**AB/7/21/L**

*Vyne Cottage 33 Mount Pleasant Arundel BN18 9BD*

*Listed building consent for the replacement of 12 No. windows & 1 No door*

1. All dimensions in millimetres (mm) and levels in metres (m) unless noted otherwise.
2. This drawing to be read in conjunction with all other relevant drawings and specification.
3. All work to comply with the relevant British Standards, Codes of Practice and the Building Regulations.

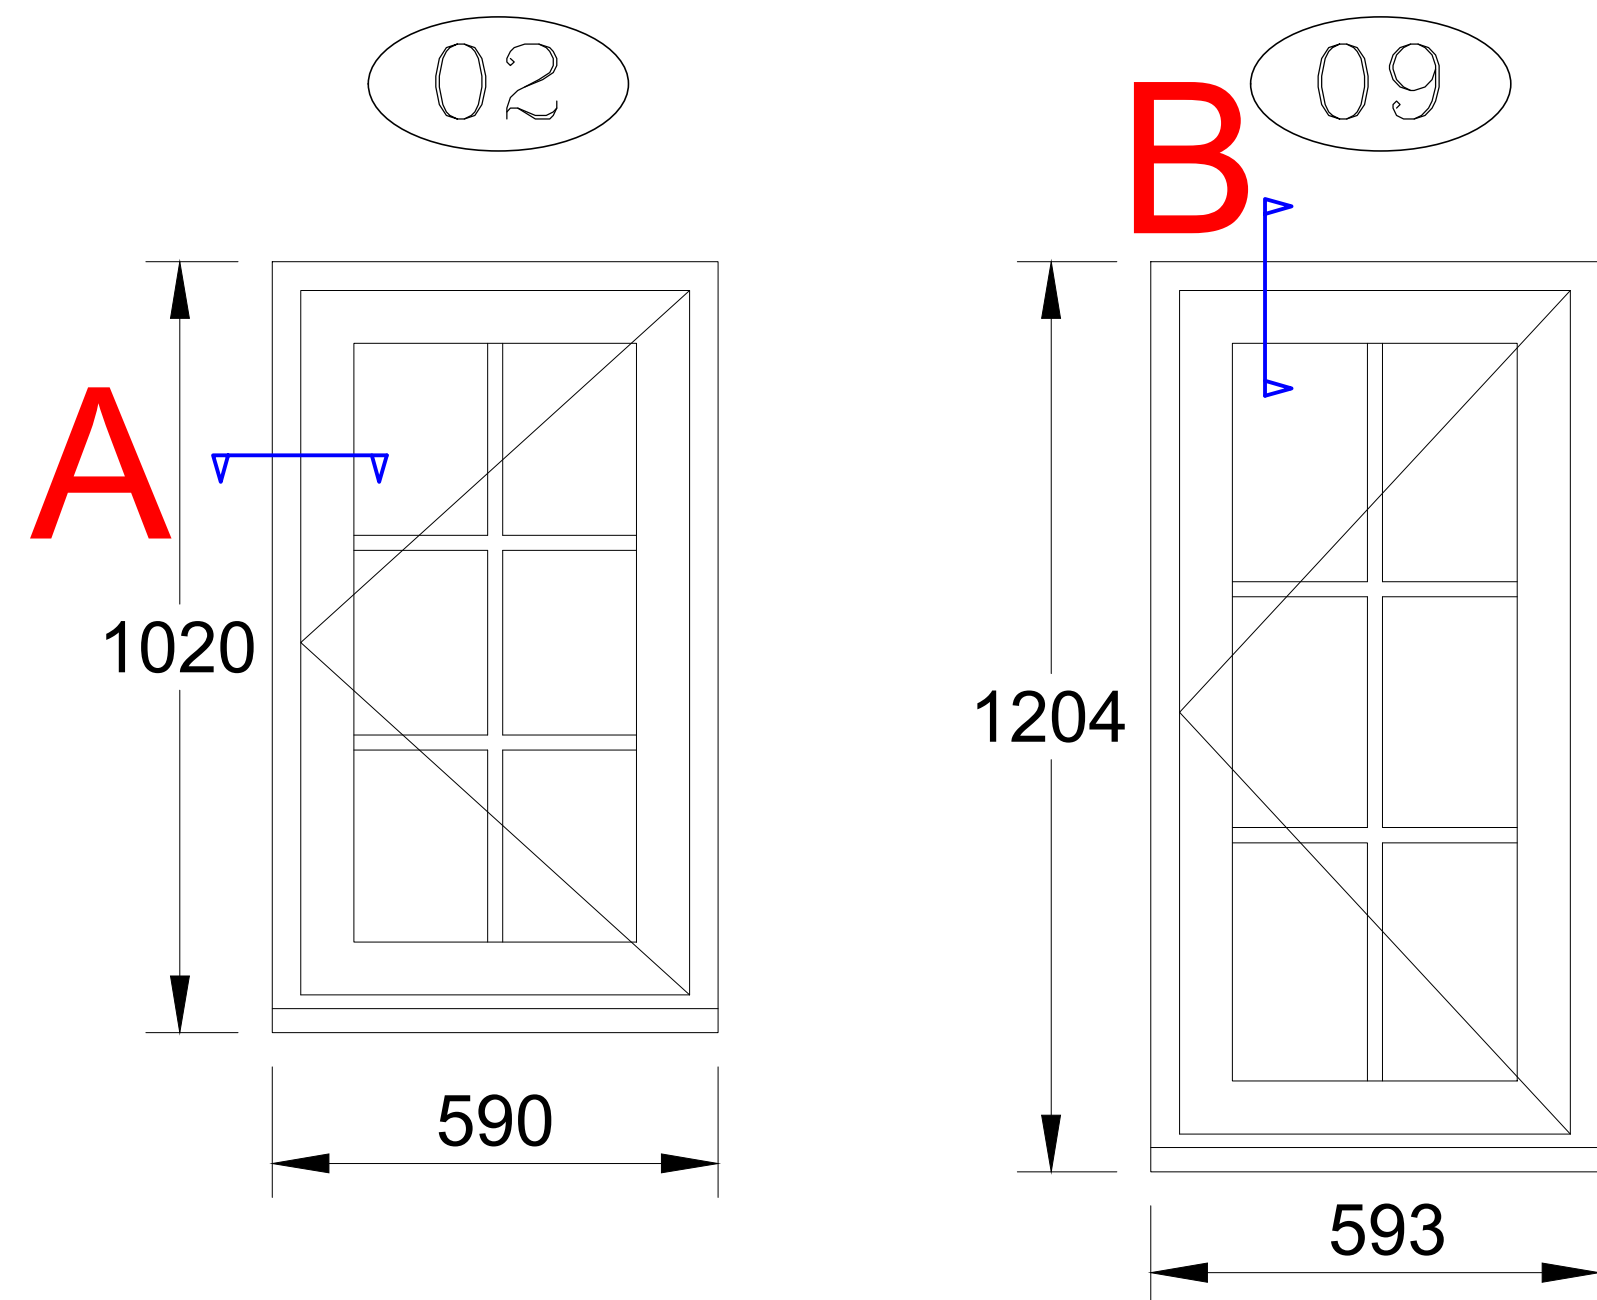
The proposal is for timber windows which incorporate 28mm double glazed units, along with the use of thermal spacers will not only increase the perception of modern, standard windows, but also affect the design of the windows themselves. Traditionally, where windows have glazing bars, these form part of the structure of the window. False glazing bars applied to the surface of the window are therefore historically incorrect, and aesthetically unconvincing. The use of applied glazing bars is therefore not appropriate for a listed building and should be integral to the windows. This type of double glazed unit and window design is therefore not appropriate for a listed building and is considered to cause harm.

An alternate approach would be to revise the design of the windows so that the much slimmer glazed units are used alongside windows/doors which include fully functioning glazing bars. However, at present of the proposal is not acceptable and is considered to be harmful.
